City of Portland, Maine - Building or Use Permit Application
 389 Congress Street, 04101 Tel: (207) 874-8703, Fax: (207) 874-8716

Permit No: 03-0475	Issue Date:	CBL: 061 G015001
------------------------------	--------------------	----------------------------

Location of Construction: 21 Storer St	Owner Name: Skwire Daniel D	Owner Address: 10 Grayhurst Pk	Phone: 874-2934
Business Name:	Contractor Name: Forrest Alden	Contractor Address: 148 Sebago Lake Road Gorham	Phone: 2078927014
Lessee/Buyer's Name	Phone:	Permit Type: Additions - Dwellings	Zone:

Past Use: Single Family	Proposed Use: Single Family	Permit Fee: \$37.00	Cost of Work: \$1,900.00	CEO District: 2	
Proposed Project Description: Construct 4' x8 Garden Shed		FIRE DEPT: <input type="checkbox"/> Approved <input type="checkbox"/> Denied		INSPECTION: Use Group: Type	
		Signature:		Signature:	
		PEDESTRIAN ACTIVITIES DISTRICT (P.A.D.) <input type="checkbox"/> <input type="checkbox"/> Approved w/Condition <input type="checkbox"/>

MORTGAGE INSPECTION OF: DEED BOOK 11334 PAGE 207 COUNTY Cumberland
 PLAN BOOK _____ PAGE _____ LOT _____

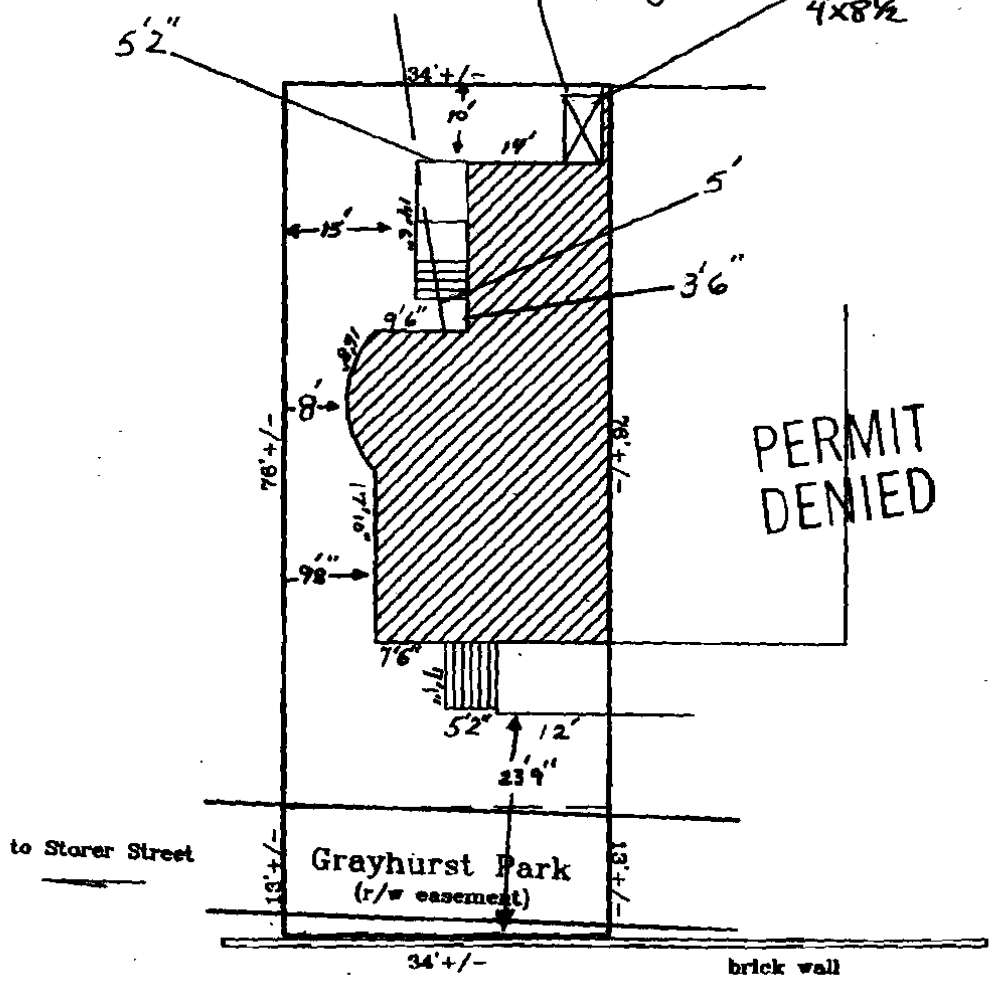
Dept: Zoning	Status: Denied	Reviewer: Jeanine Bourke	Approval Date:	Ok to Issue: <input type="checkbox"/>
Note: 5/14/03 left vm w/owner to call as the shed does not meet setbacks and they already exceed lot coverage 5/14/03 Dan Skwire called back to give more info on shed & I told him I would check w/Marge 5/22/03 left vm w/ Dan S. To say that the shed will not meet the 5' setback and lot coverage is already exceeded, permit denied				
Dept: Building	Status: Denied	Reviewer:	Approval Date:	Ok to Issue: <input type="checkbox"/>
Note:
